# State Significant Development Application - SSD 6554 Response to Submissions/Preferred Project

## Block 1, Central Park

### Mixed Use Residential Development

Submitted to Department of Planning and Environment  
On Behalf of Central Park JV No 2

Revised Tower Façade Design - Loggias vs Balconies

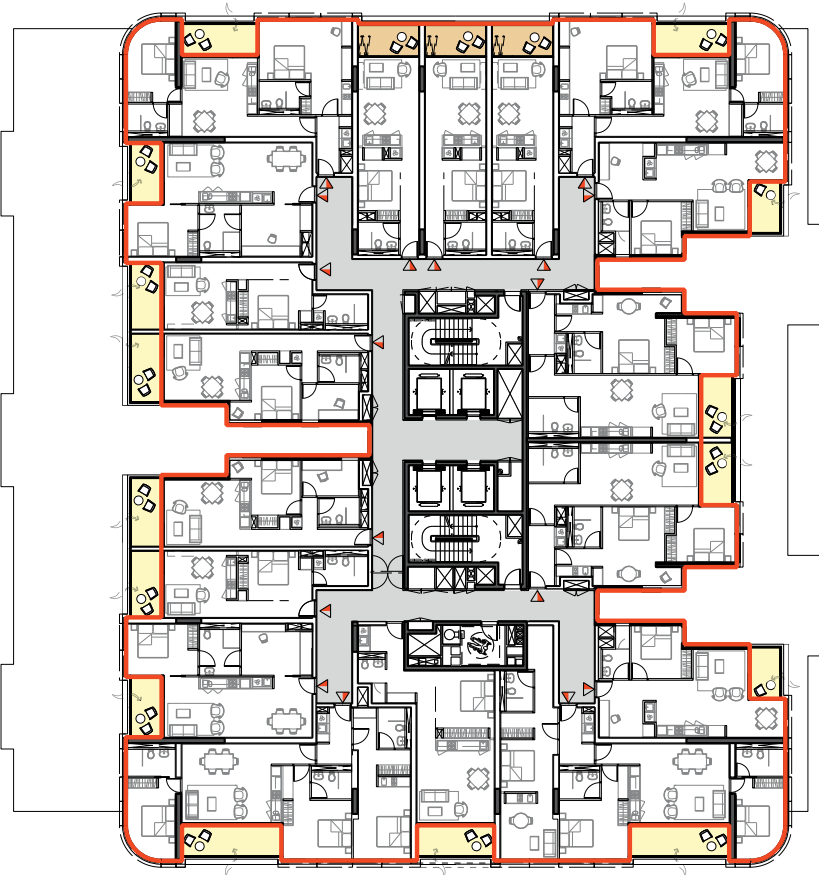
The design of all northern facing apartments has been amended from balconies to loggias, assisting in the provision of solar access, mitigating noise impacts, and increasing apartment sizes, whilst providing flexibility in the use of the space for occupants.
